Tel 0300 123 6780
Email developeras@lancashire.gov.uk
Your ref 3/2021/0660-0661
Our ref 3/2021/0660-0661/DRW1
Date 25th October 2021

Application No: 3/2021/0660 AND 3/2021/0661

Location: BOWLAND SECTION AND MARL HILL SECTION. WORKS AT VARIOUS LOCATIONS.

Proposal: PROPOSED WORKS FOR AND USE OF REPLACEMENT SECTION OF AQUEDUCT, INCLUDING EARTHWORKS AND ANCILLARY INFRASTRUCTURE INCLUDING: A NEW VALVE HOUSE BUILDING WITHIN FENCED COMPOUND WITH PERMANENT VEHICULAR ACCESS PROVISION. WITH THE INSTALLATION OF A TUNNEL PORTAL AND AN OPEN CUT CONNECTION AREA WITHIN A TEMPORARY CONSTRUCTION COMPOUND, TO INCLUDE SITE ACCESSES, SOTRAGE AREAS, PLANT AND MACHINERY, AND DRINAGE INFRASTRUCTURE AND A TEMPORARY HAUL ROUTE WITH BRIDGE OVER THE RIVER HODDER. IN ADDITION, A TEMPORARY HAUL ROUTE WITH BRIDGE OVER THE RIVER RIBBLE (AS ONE OF TWO OPTIONS FOR VEHICULAR ACCESS TO THE TEMPORARY CONSTRUCTION COMPOUND); A SERIES OF LOCAL HIGHWAY WORKS TOGETHER WITH A TEMPORARY SATELLITE PARK AND RIDE FACILITY AND A VEHICLE MARSHALLING AREA.

NEWTON-IN-BOWLAND AND MARL HILL COMPOUNDS HIGHWAYS WORKS

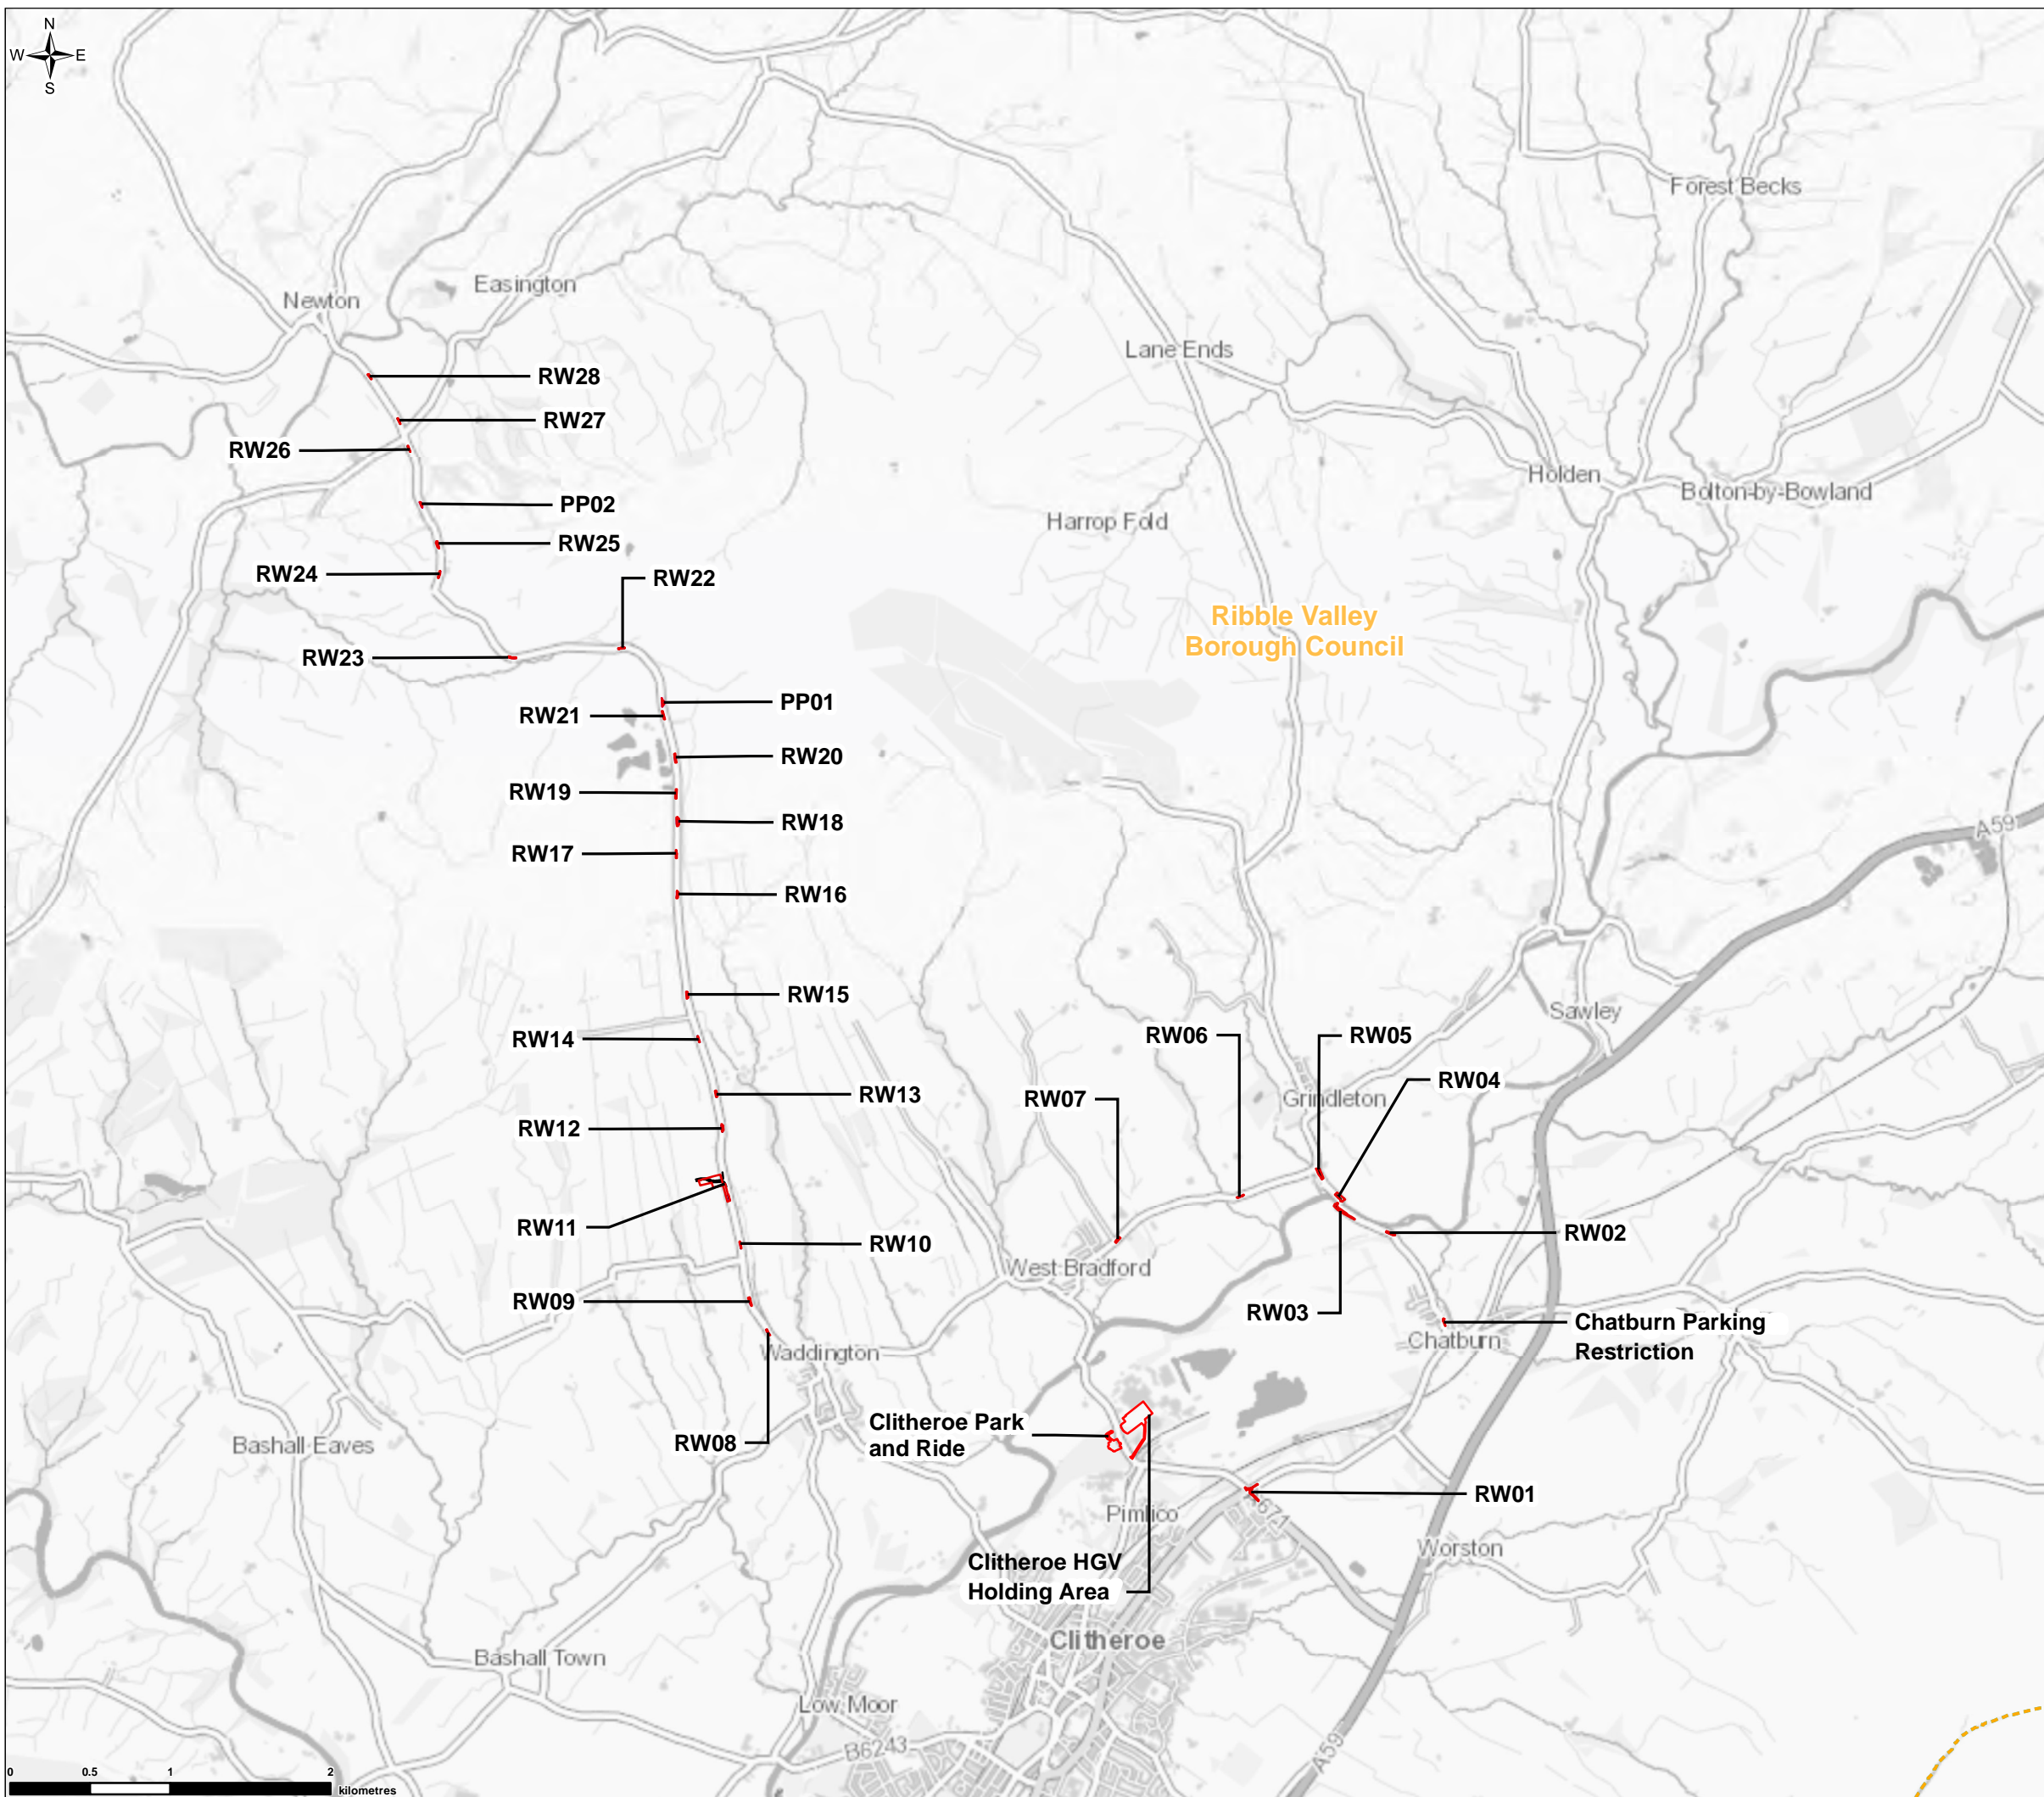
Drawing RVBC-BO-FIG-V5-P1-001 (Highways Works - Master Plan Page 1 OF 1) provides a plan of the full routes with the labelled road widenings, passing places, HGV Holding Area, Park and Ride area and Chatburn Parking Restriction. **I would note that the necessary parking restriction proposed on West Bradford road (shown in Figure B-2-15 of the CTMP) is missing from Highway Works Masterplan drawing and from the Offsite Highway Works drawings.**

- I would request clarification in the gap in tracking on FIGURE B - 1 – 10
 - **While a small label on drawing RVBC-BO-FIG-V5-P1-001 indicates a Parking Restriction in Chatburn, I have been unable to identify any further detail regarding this proposal (e.g. highlighting the extent of the proposed parking restriction and/or proposed provision for displaced parking).** Image 3 on FIGURE B - 1 – 10 highlights the need for the parking restriction.

SCALE N.T.S.	SHEET SIZE A3
DRAWING NUMBER RVBC-BO-APP-004-12_11	REVISION 0

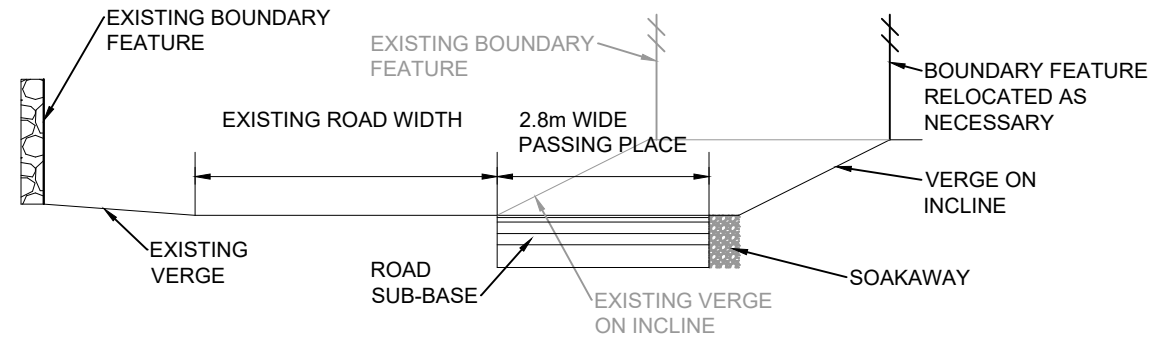
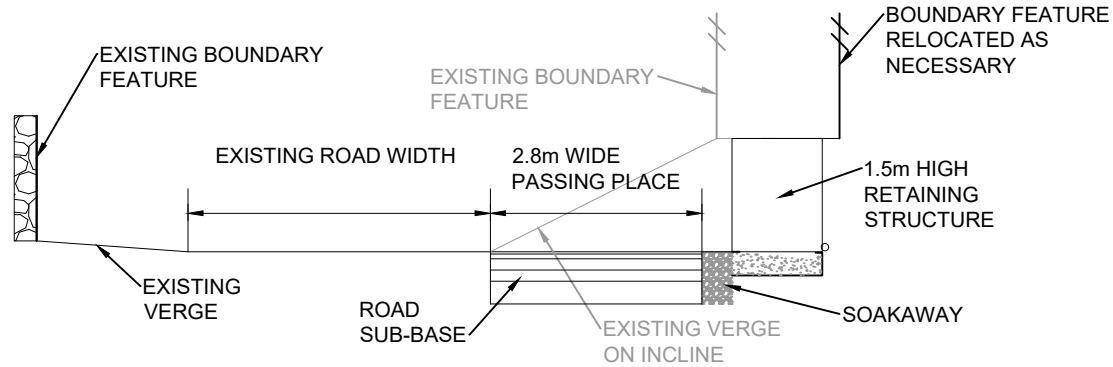
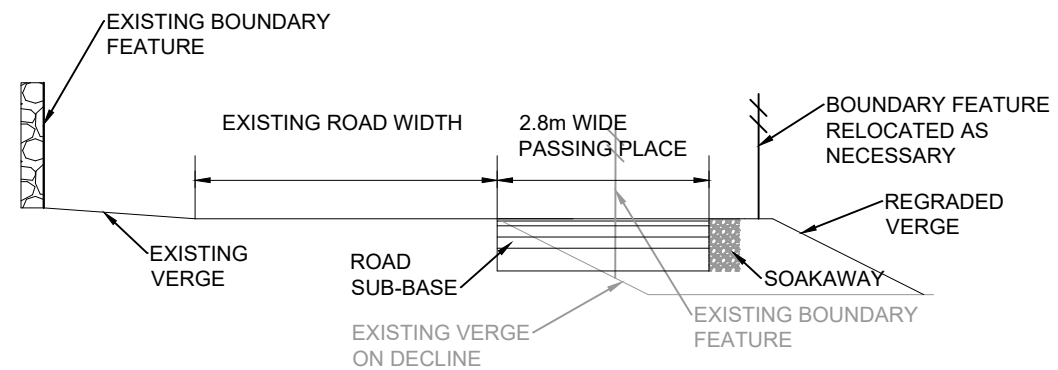
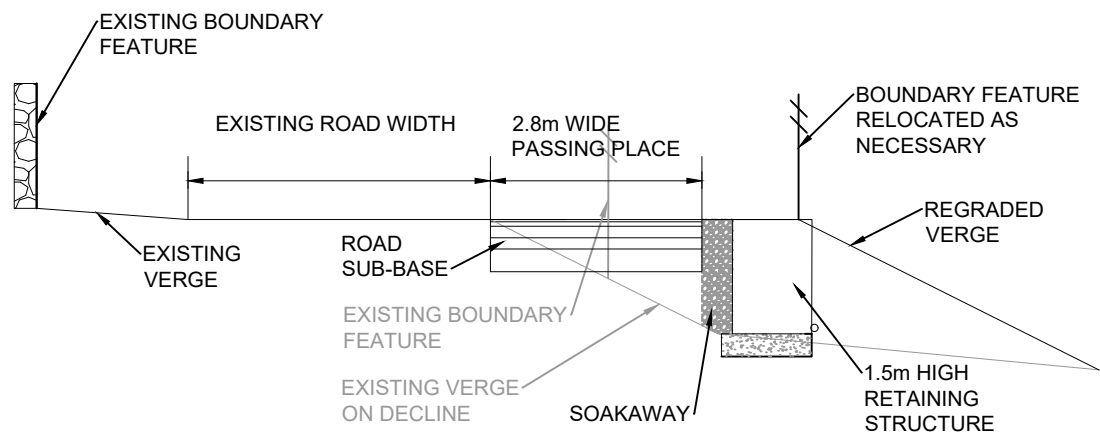
Drawings RVBC-BO-APP-004-12_01 to 10 (Highways Works Proposals Sheets 1 to 10) show wider details of the road widenings and passing places, with the types of works labelled. Drawings RVBC-BO-APP-004-12_11 to 12 (Highways Works Proposals Sheets 11 to 12) show the typical passing place and road widening cross sections.

Volume 5 of the ES (Newton-in-Bowland and Marl Hill Compounds Highways Works Part I: Environmental Assessment (excluding Ecology)) sets out the design approach for the proposed offsite highway works. While this document sets out the design criteria for passing places, it is unclear how the judgements have been made in regard to sight stopping distance and drivers' ability to judge whether to use a passing place or continue when forward visibility does not assist the decision (evidence base is needed to support any engineering judgements that can stand up to external scrutiny). The location of the passing places must account for driver visibility of oncoming vehicles and drivers' judgements of the need to use the road widenings, in the placement of places. This information is currently not provided but required.

SCALE N.T.S.	SHEET SIZE A3
DRAWING NUMBER RVBC-BO-APP-004-12_12	REVISION 0

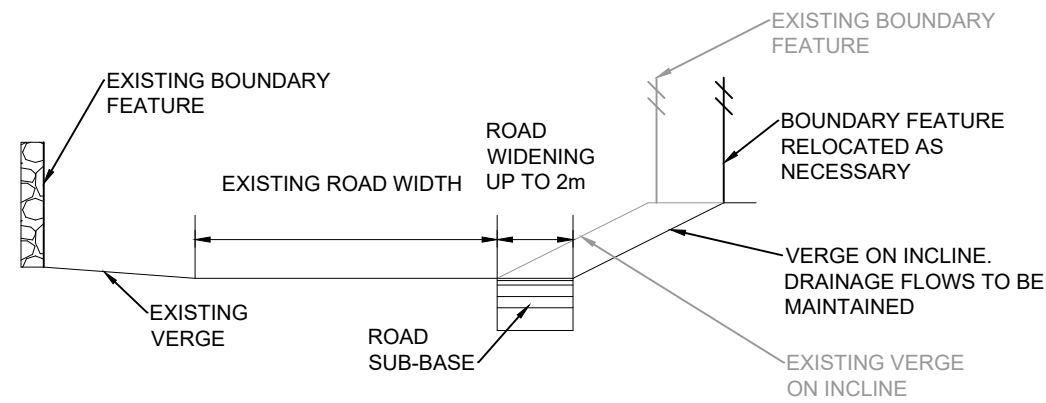
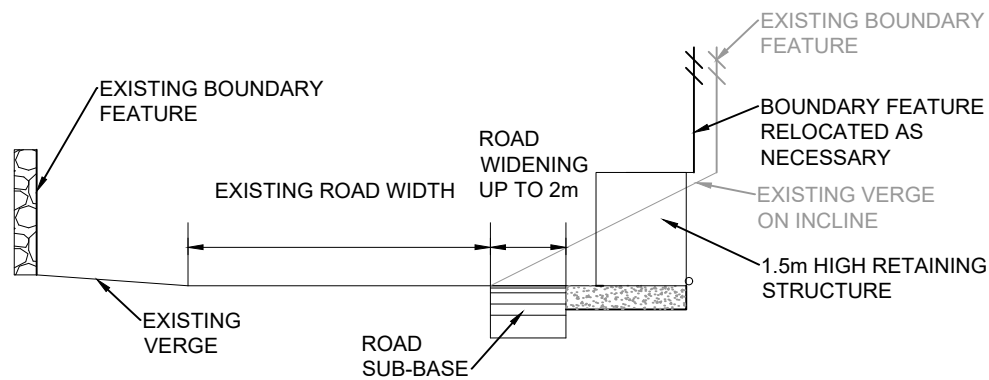
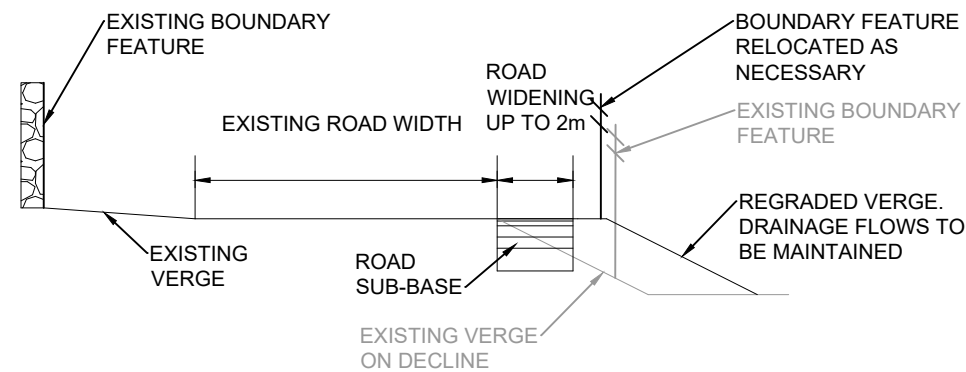
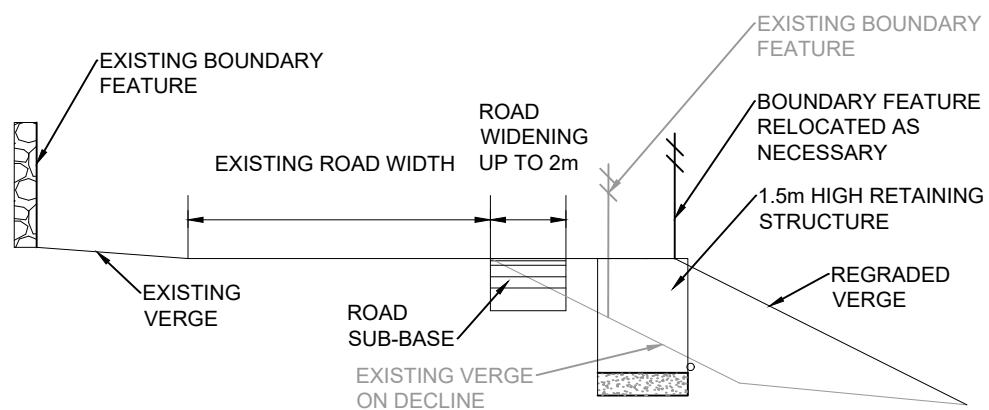
- RW02 - there is no detail that clearly explains the issue and the detail of the proposal and how this overcomes the issue. I would note that RW02 is over a short distance, whereas the tracking suggests that that widening is needed up to RW03.
